KIRKLEES METROPOLITAN COUNCIL INVESTMENT & REGENERATION SERVICE

DELEGATED DECISION TO DETERMINE APPLICATIONS FOR NON-MATERIAL AMENDMENTS

Reference No: **2024/NM/92974/W**

Site Address: Greenhead College, Greenhead Road, Huddersfield,
HD1 4ES

Approval
 Submitter: Construction
 Project: Galliford Try Greenhead College Huddersfield
 Drawing: Courtyard Infill - Rendered GA Elevations

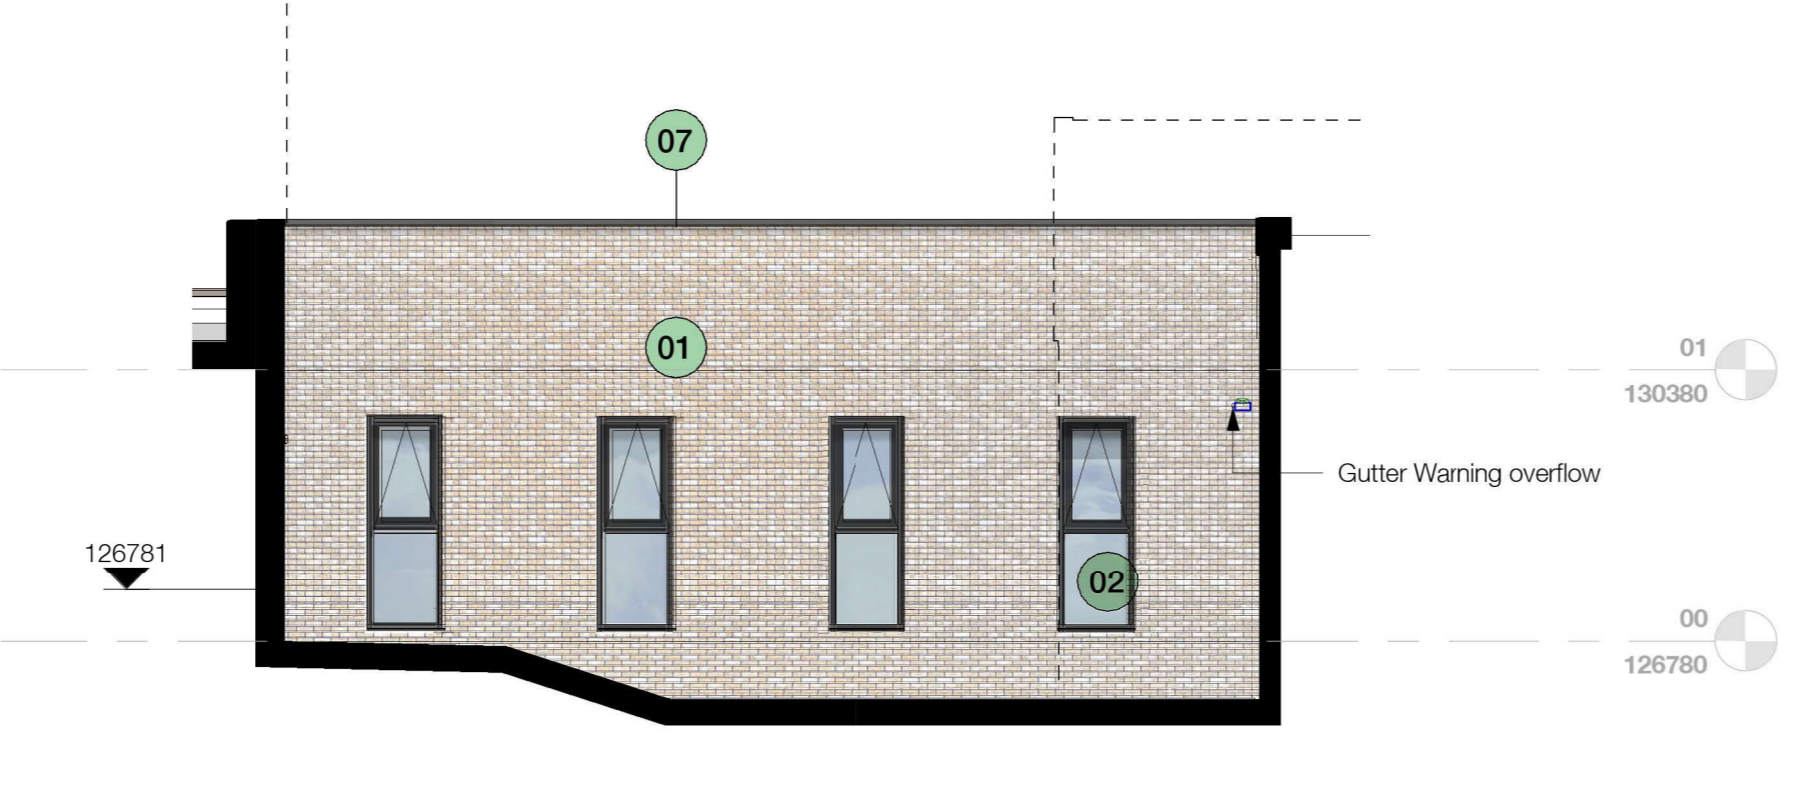
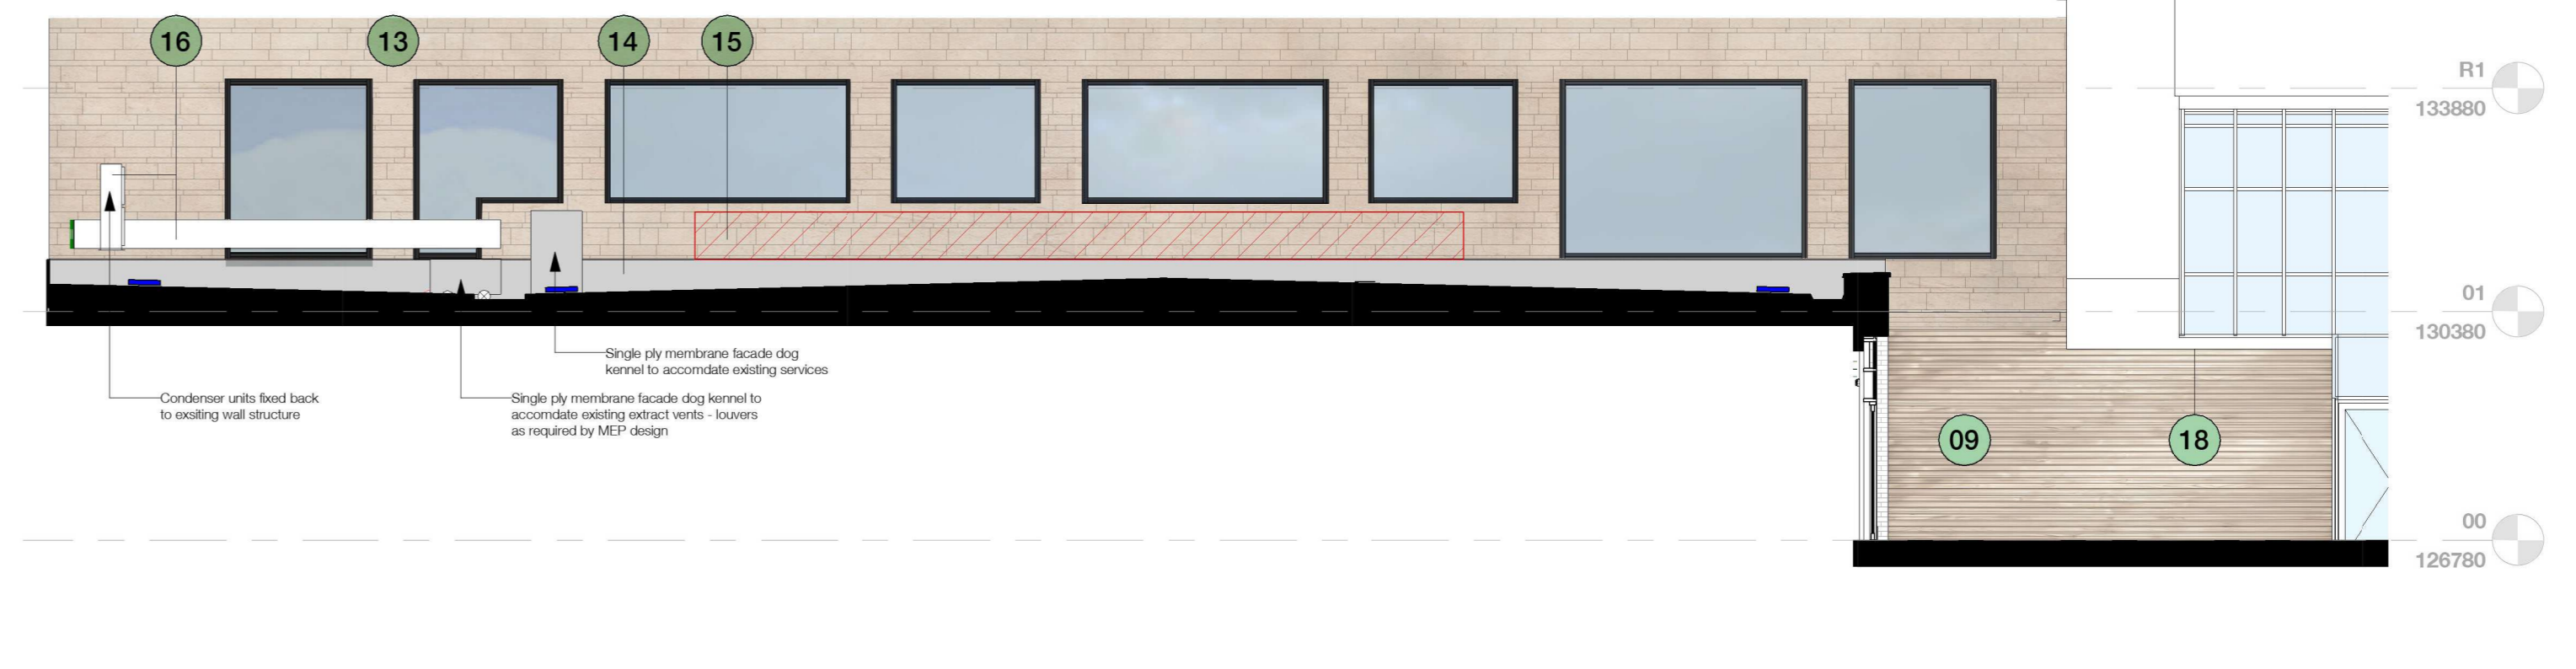
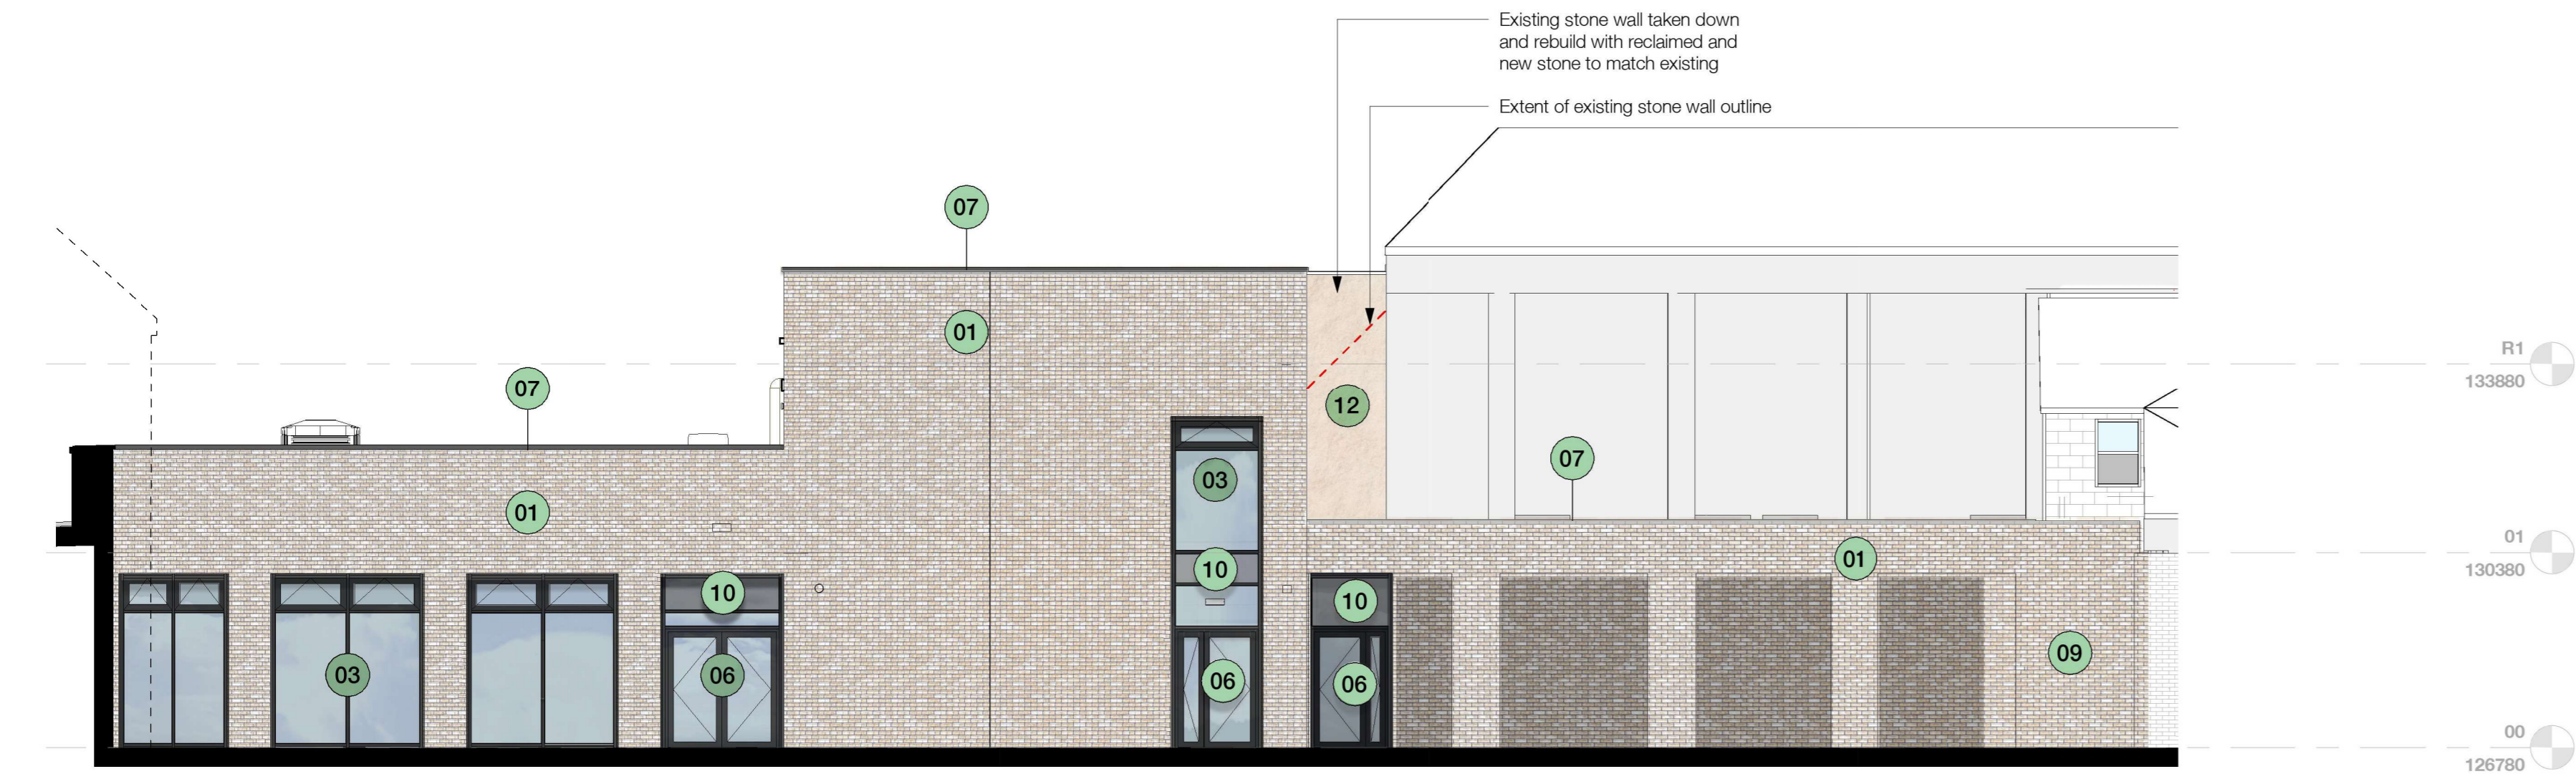
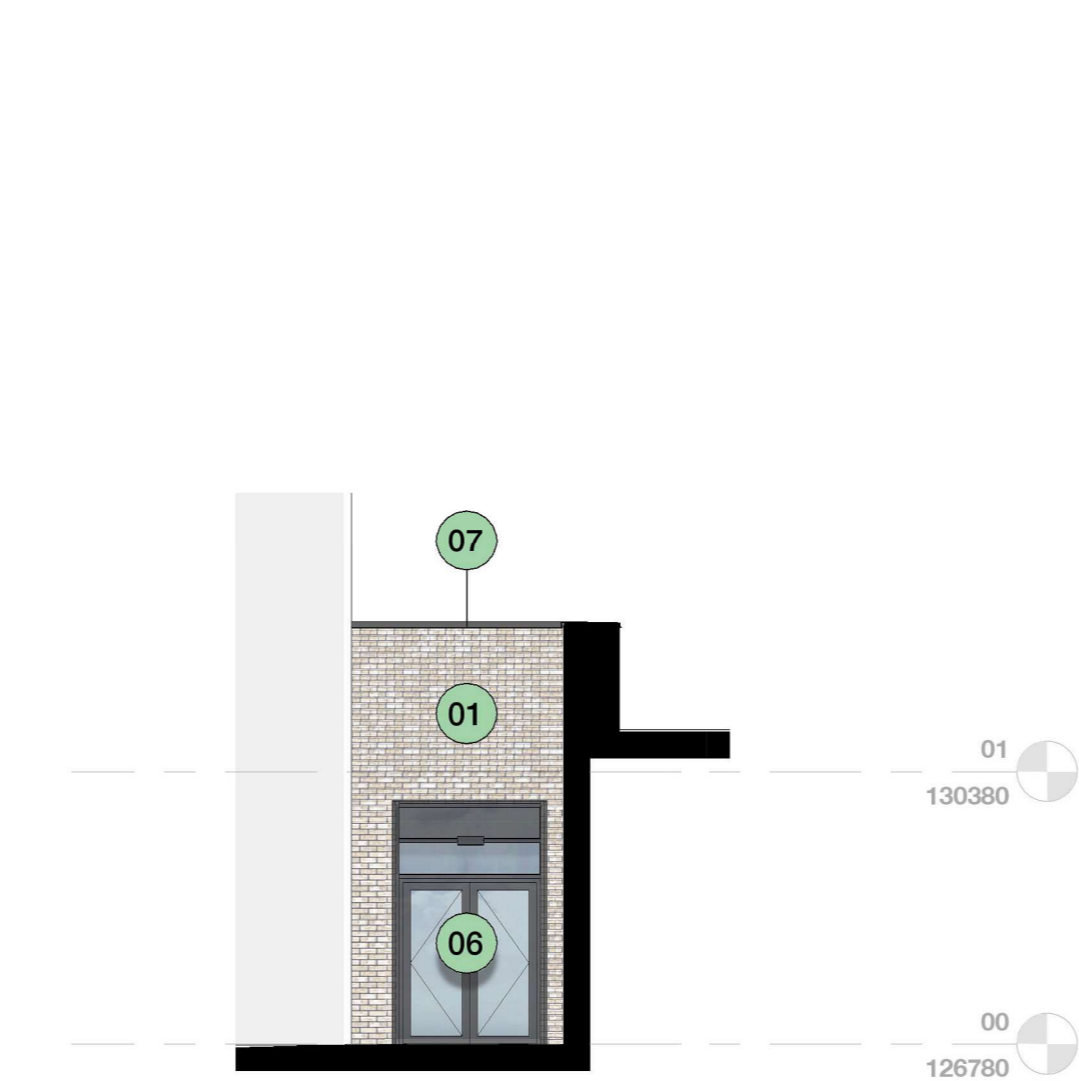
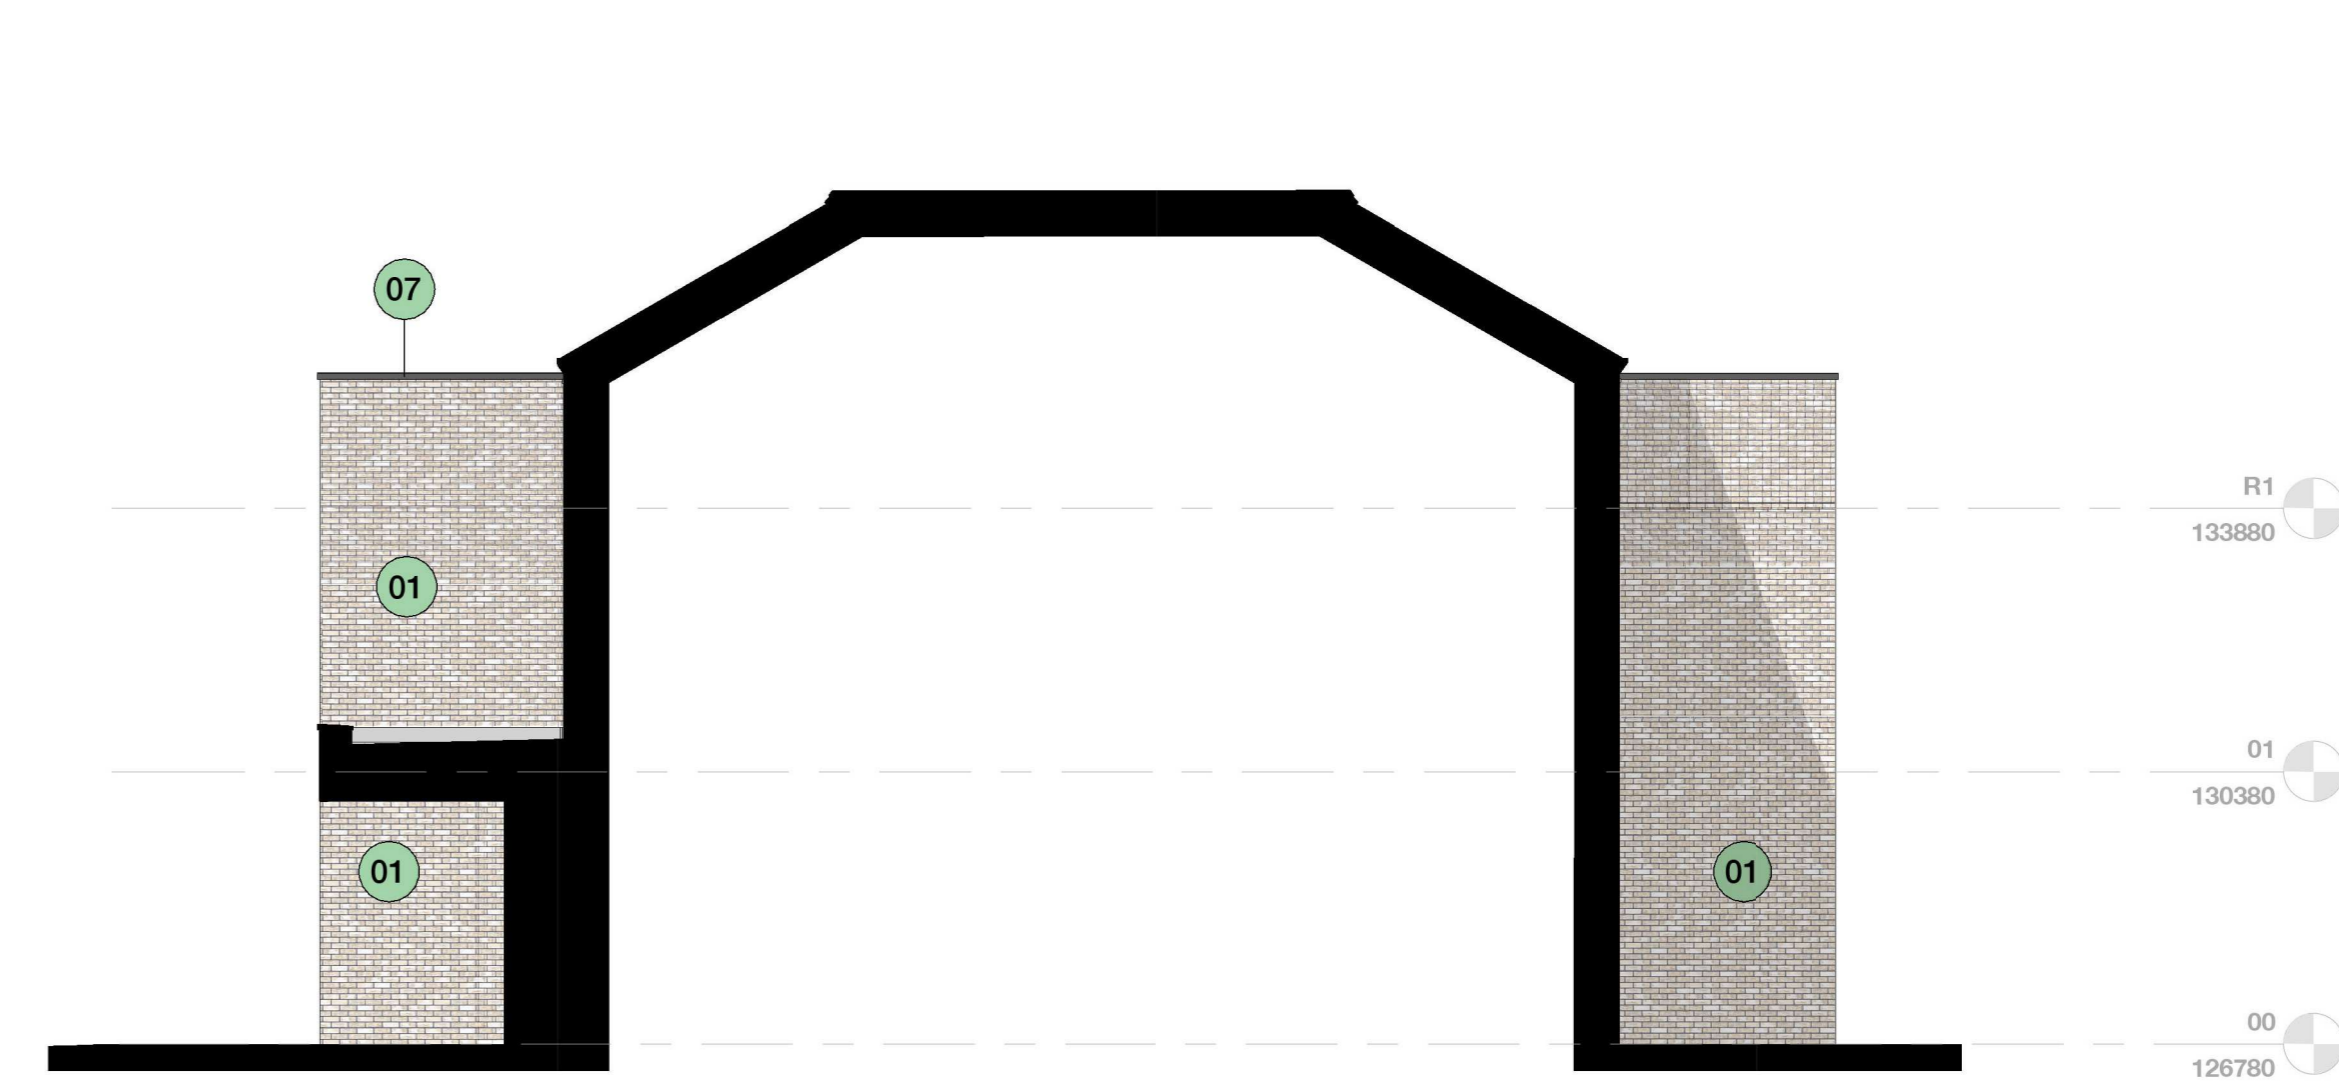
- *Additional duct work through roof to align with developed MEP design – the ductwork will not extend above the parapet.*
- *Revised configuration of air source heat pumps (ASHPs) and related services to gutter line to suit developed MEP design.*

- *New air handling units (AHUs) located on the roof of the new building due to a client instruction to replace existing end-of-life units. The new units and ductwork will not extend above the parapet so will be visually screened. This results in the incorporation of the existing pitched roof into the new building parapet.*

- *Existing sloping parapet extended to create a flat top to guard roof edge and conceal AHU and ductwork from view.*
- *Updates to indicate surveyed existing building lines and retained building footprint.*
